EAST PRESTON PARISH COUNCIL

16th July 2009

Re: EP/90/09, Churchfield, Station Road, East Preston

At its meeting on Monday, 13th July, the Planning Committee of this Parish Council agreed to object to this Application on the following grounds –

Boundary Treatments

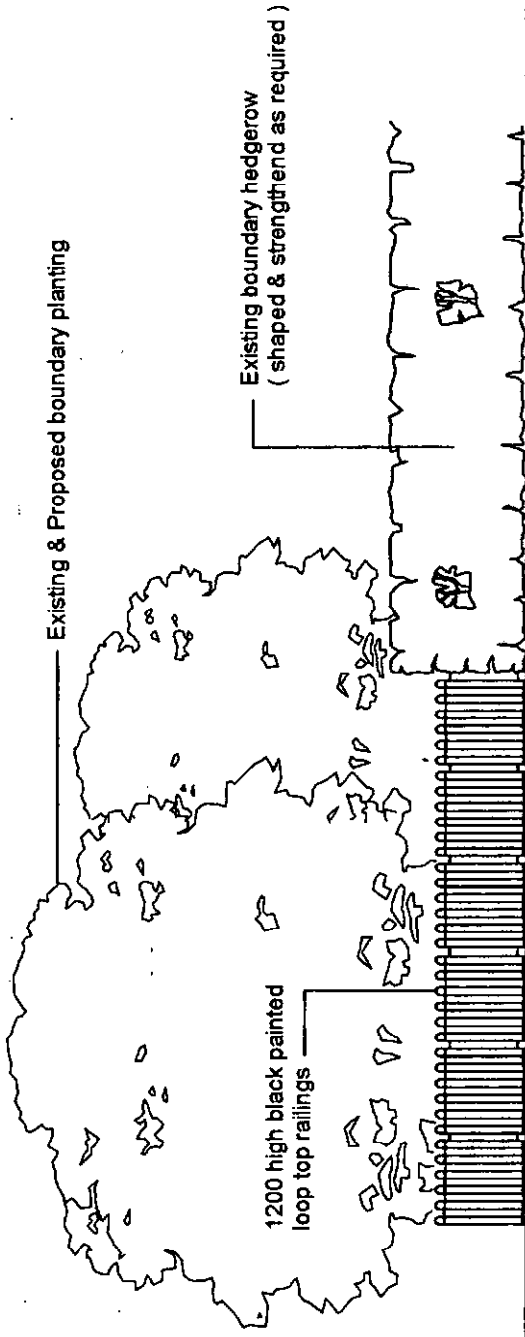
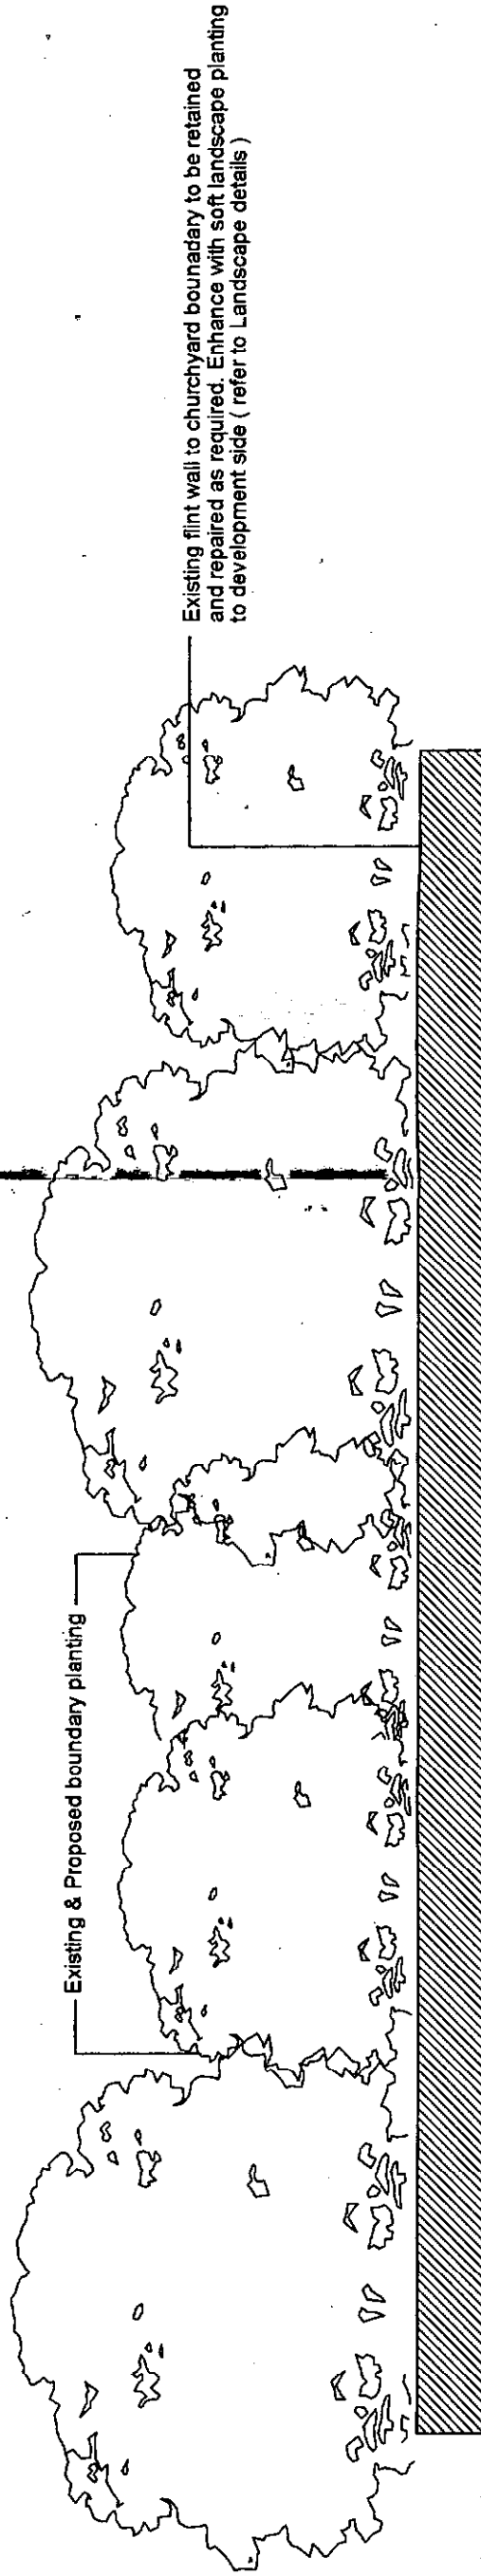
6. The proposed boundary treatment of loop top railings to the east and west boundaries would be out of keeping and unsympathetic to the street scene and conservation area and the rural setting of Langmead Recreation Ground.
7. The proposed development which is essentially urban in appearance also constitutes an overdevelopment of the site, would clearly not be in harmony with the local environment and would not enhance the characteristics of an area that is valued.

" Church Field " Station Road, East Preston
Typical Sections

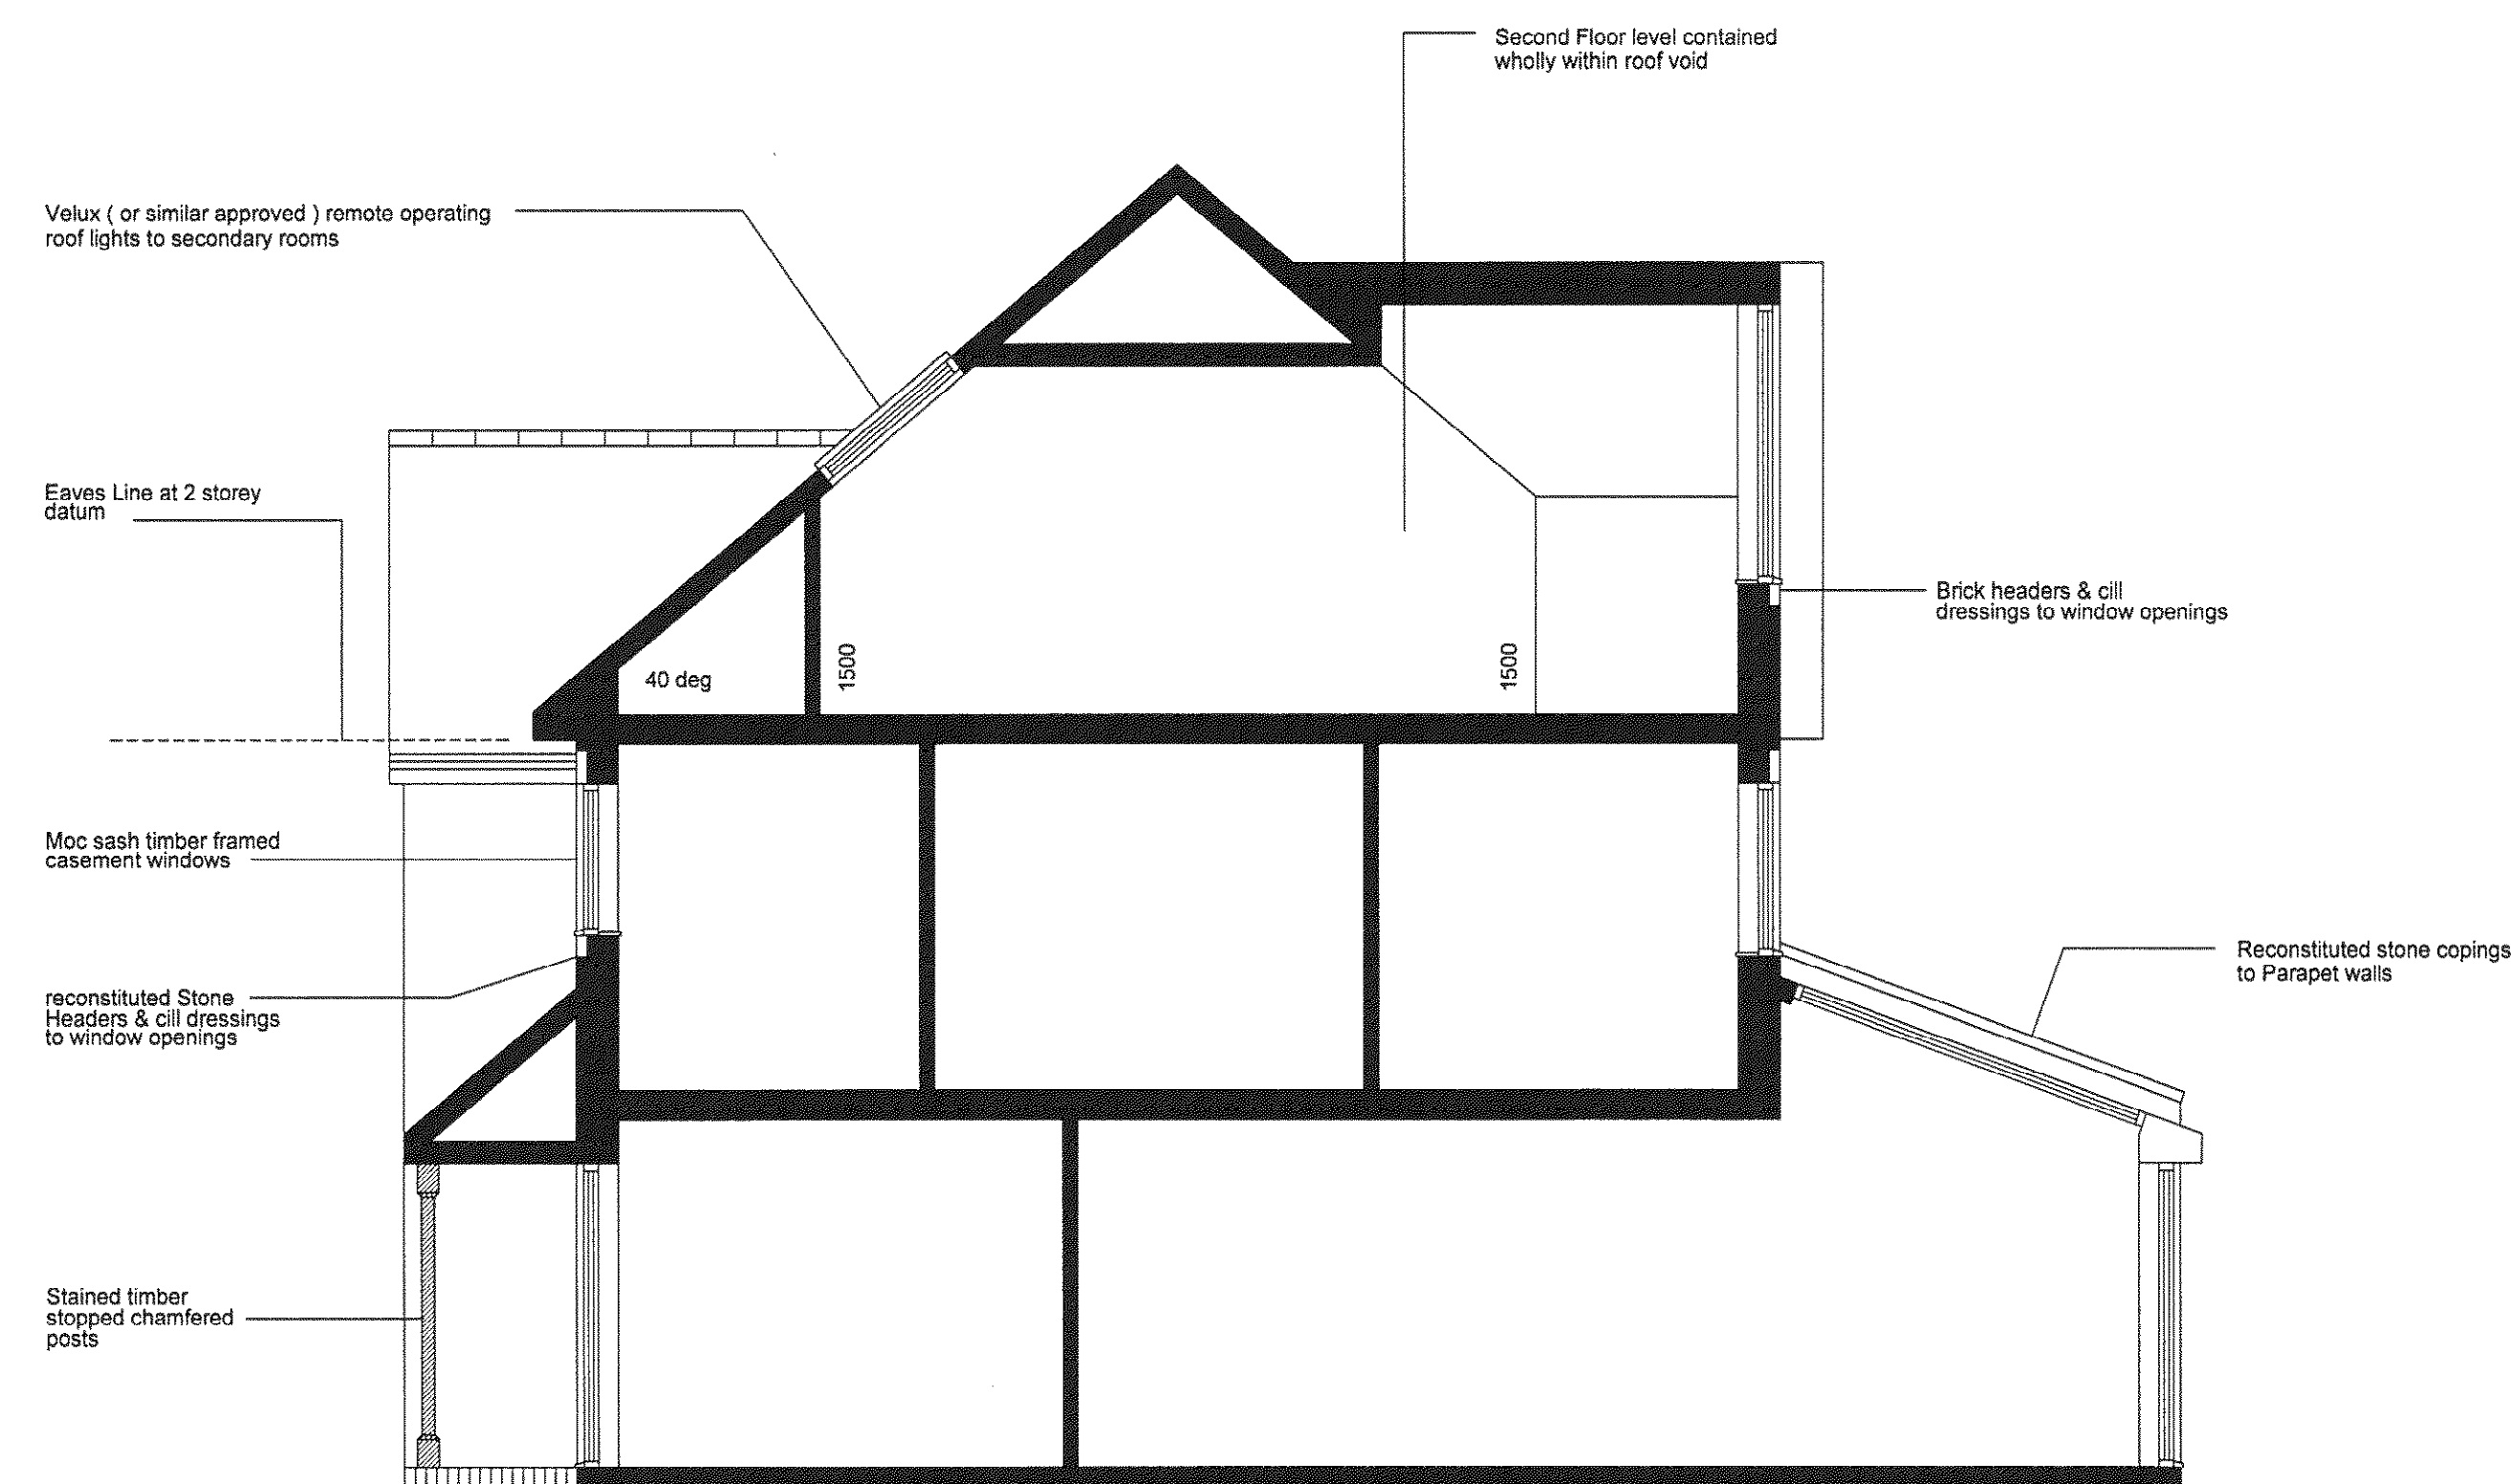
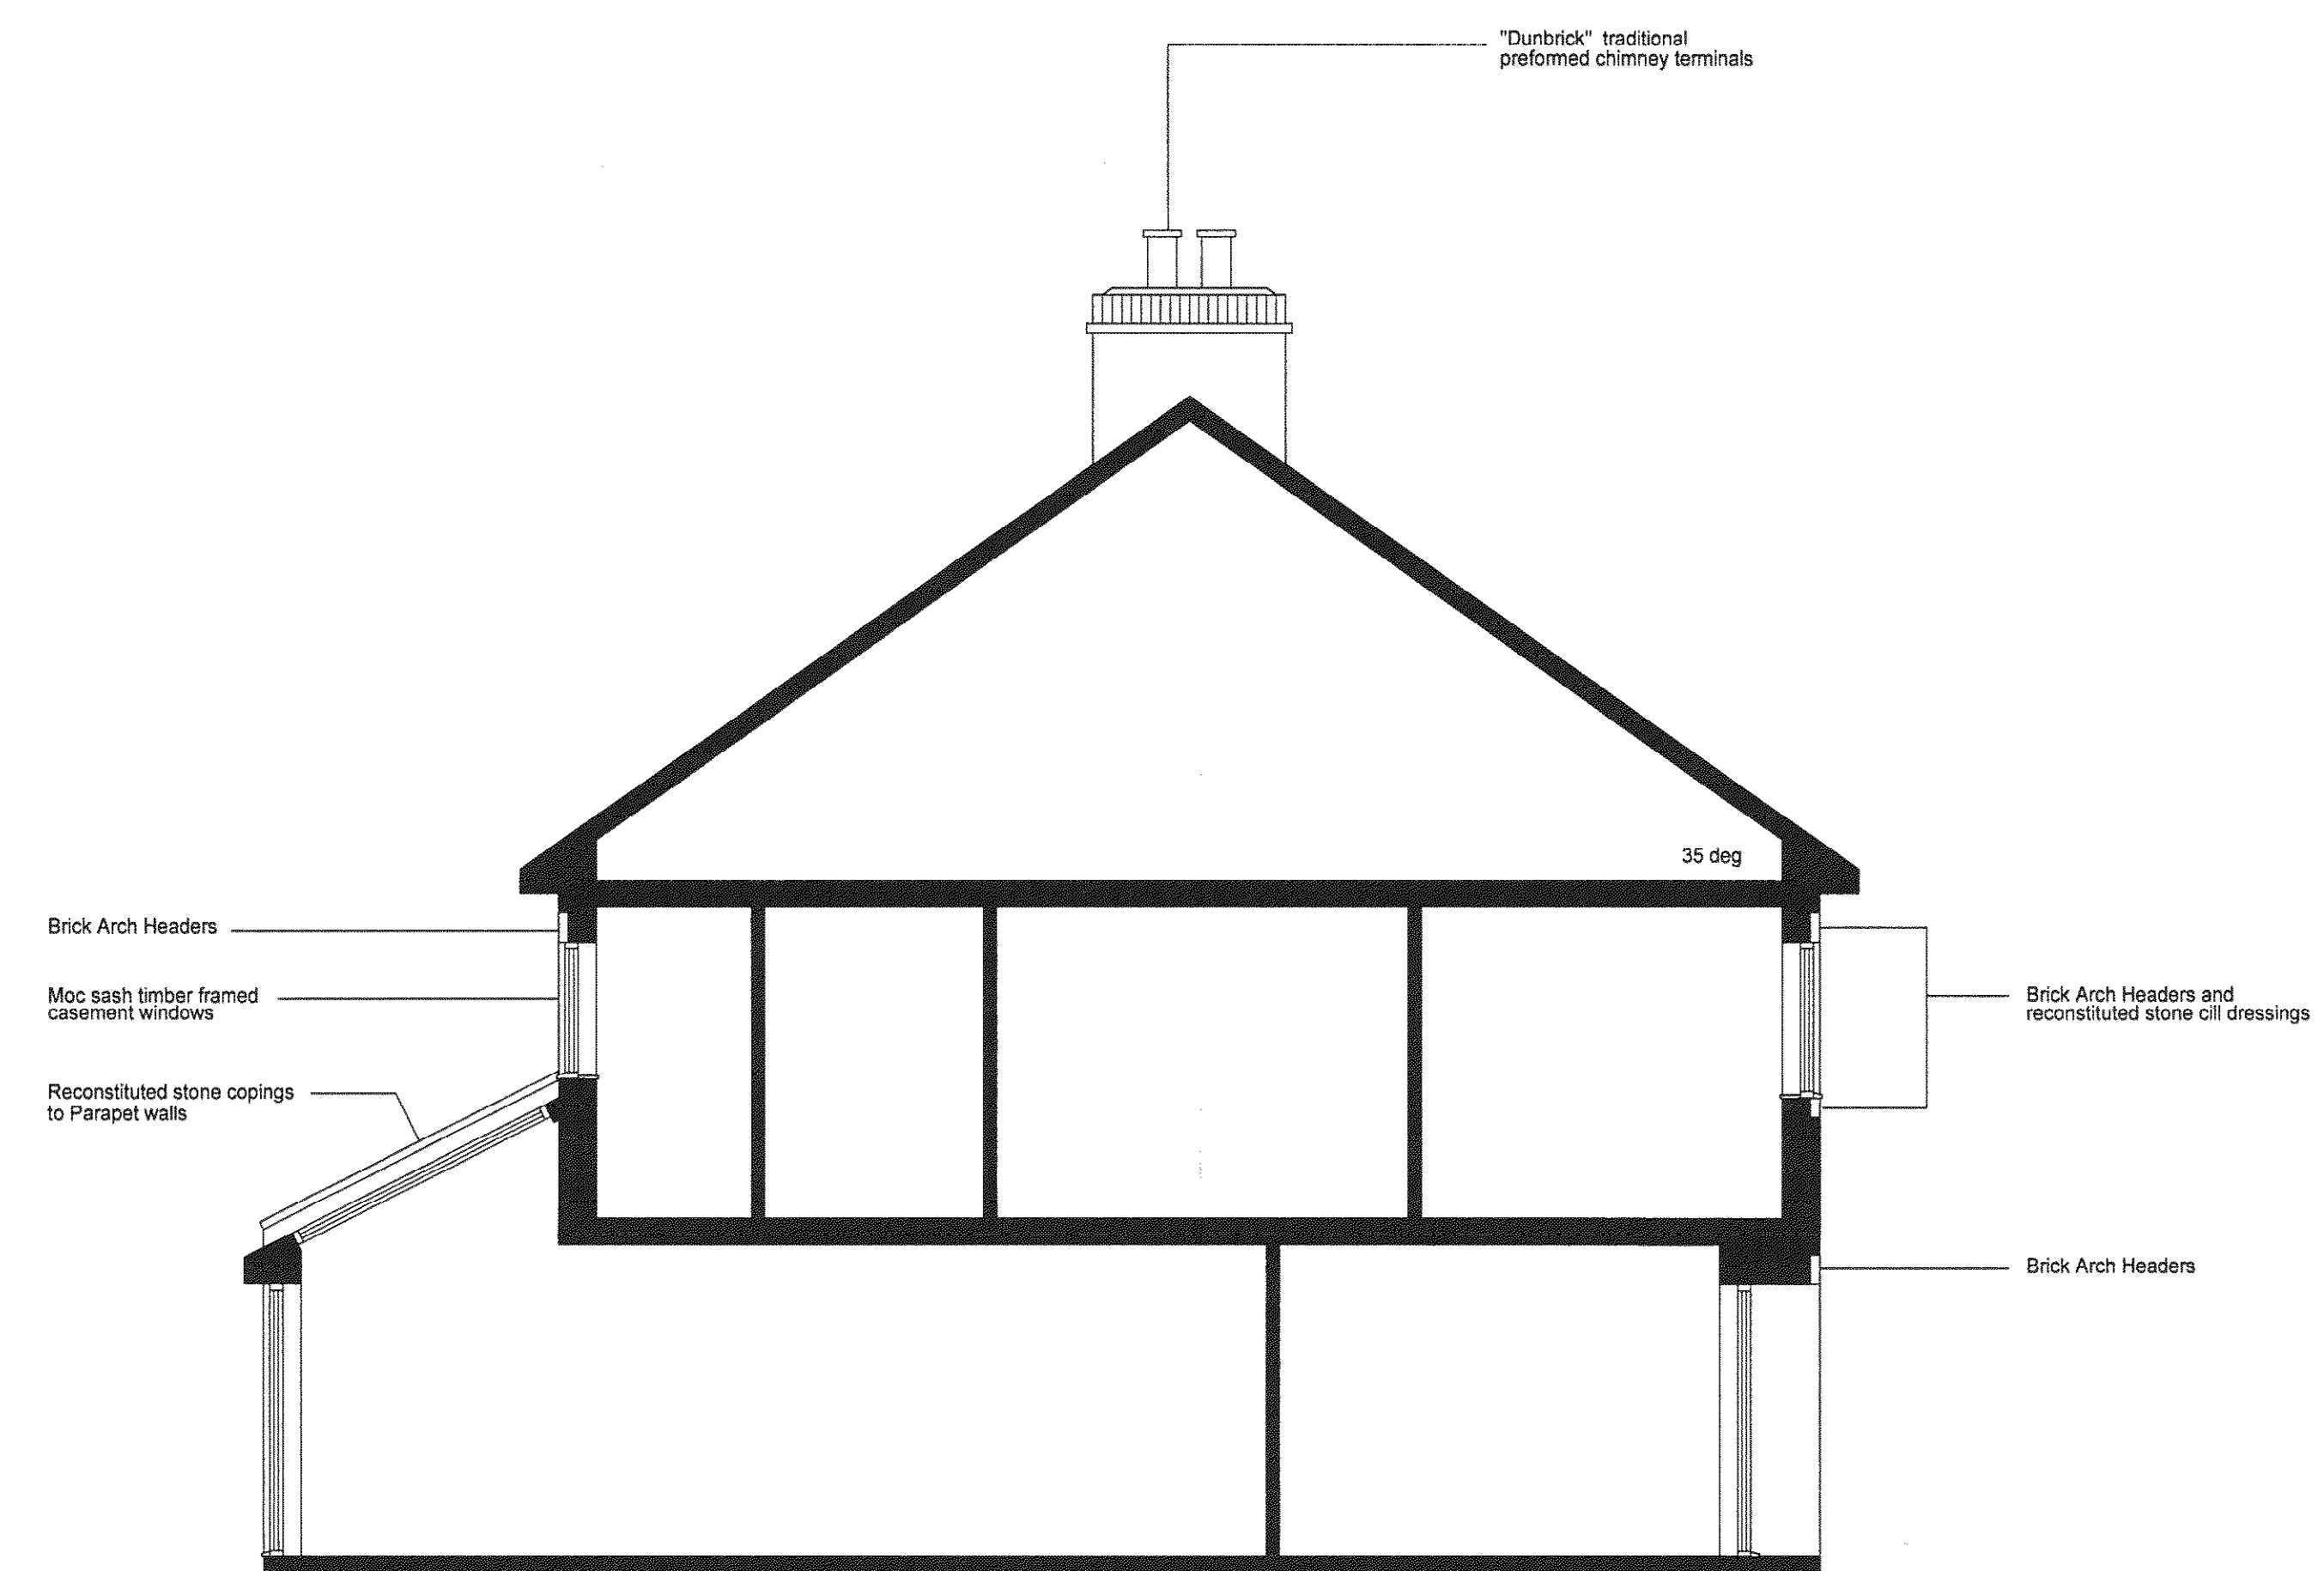
2. The proposed building of a terrace of 2½-storey modern terraced houses and the end of a block of 2½-storey flats, both brick and tile hung rendering, close to the boundary of the church conflicts with policies GEN 7 and DEV 11 of the Local Plan. The urban style buildings do not respond positively to the characteristics of the site and does not respect and enhance the special qualities of the 12th Century Grade 1 Listed Church. Although the proposed tree planting will partially screen the buildings, if the trees were removed the setting of the Listed Building would be damaged by the inappropriate development.
